From: Amanda Scholes on behalf of Planning.Responses
Sent: 26 July 2017 10:28
To: Planning Scanning
Subject: FW: Fitzalan Link - LU.234.16.RES

Following review of the submission, WSCC comments as follows:

In summary, there appear to be just three outstanding points now – the choice of road surface, the requirement for a new or supplementary Stage 1 Road Safety Audit and the design of the shared footpath-cycleway connection to Highdown Drive close to the new

| title  | PUBLIC RIGHT OF WAY DIVERSION PLAN |

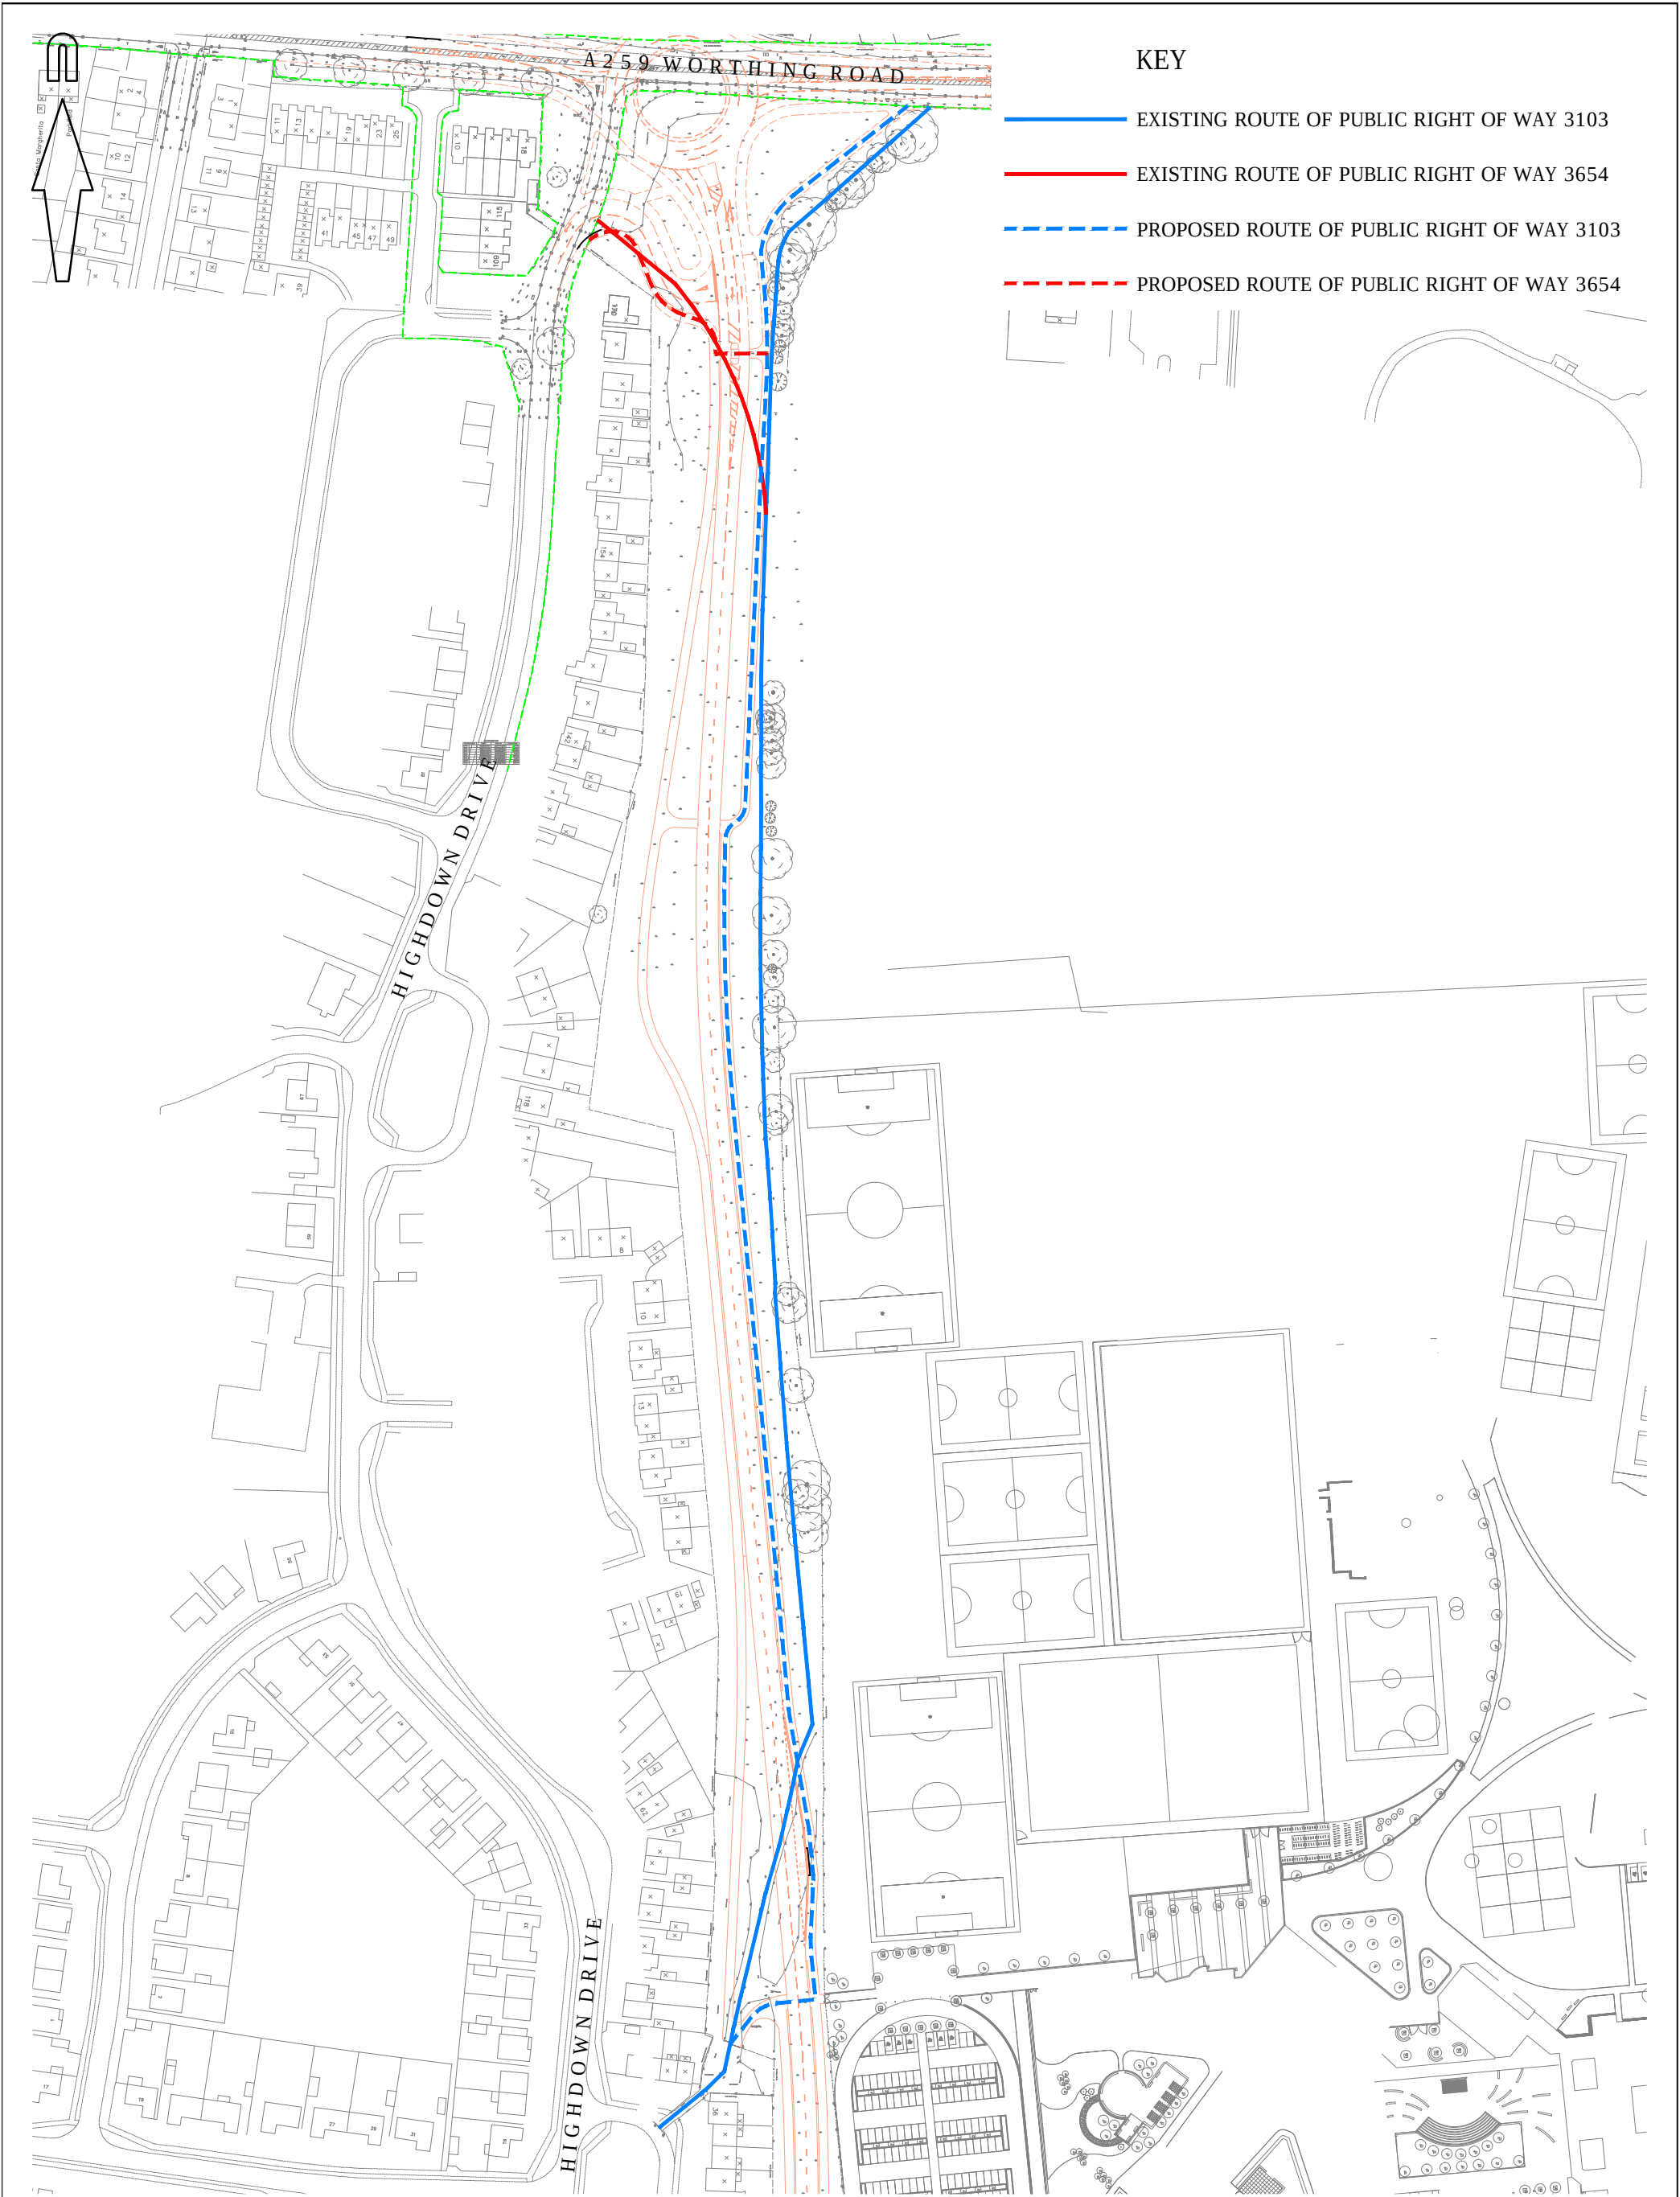
You have again offered an explanation for the path alignment in the vicinity of the Toucan crossing and balancing pond. The radii proposed are acceptable to us but the path must connect properly to the path leading to Highdown Drive which should be upgraded to a shared footway-cycleway. I have indicated below what this might look like. However, looking at this again shows the pink area to be public highway and on the line of part of Public Footpath 3103. Therefore, it is recommended (and indeed appears more straightforward) to retain this line otherwise it appears that any continuation of the route south of your scheme might cross land that might not be highway. Any path should be lit, edged, resurfaced, signed and tactile-paved appropriately although these final details can be shown at the S38/278 stage. Any upgrade from Public Footpath to shared footpath-cycleway must be undertaken in-accordance with WSCC PRow procedures.

Public Rights of Way (PRoW).

Any changes to formal PRoW (temporary and/or permanent) must only be undertaken following appropriate WSCC processes and/or procedures and obtaining all necessary permissions – some of which are often separate from any planning application processes. Full details can be obtained directly from the PRoW team here at WSCC.

The highway boundary plan and alignment of the existing PRow is noted. However, this is not evident on the ground since the Academy has been constructed (see extract from Google Earth below). We can show the alignment requested, (based on the OS Highway Boundary plans provided) but we would only have the power to construct the pathway up to our limit of ownership (the red line). WSCC has less than Freehold rights beyond the red dashed line and as such we don't believe we would have any power to undertake works on this area of land (see attached) to effect the PRow route beyond the red line, hence the reason for showing the tie-in (at the limit of ownership) to the existing physical route present on the ground. Therefore, we believe that what we have shown on the submitted drawings is the best solution, unless WSCC can confirm that we could legally obtain power to undertake works on land that they don't have complete freehold rights over.

I have already sent a note on this. We will be submitting the diversion request under the TCPA to ADC. Once plans for the Fitzalan Link have been confirmed / approved I will start this process with relevant personnel at ADC. It is not a matter for WSCC.
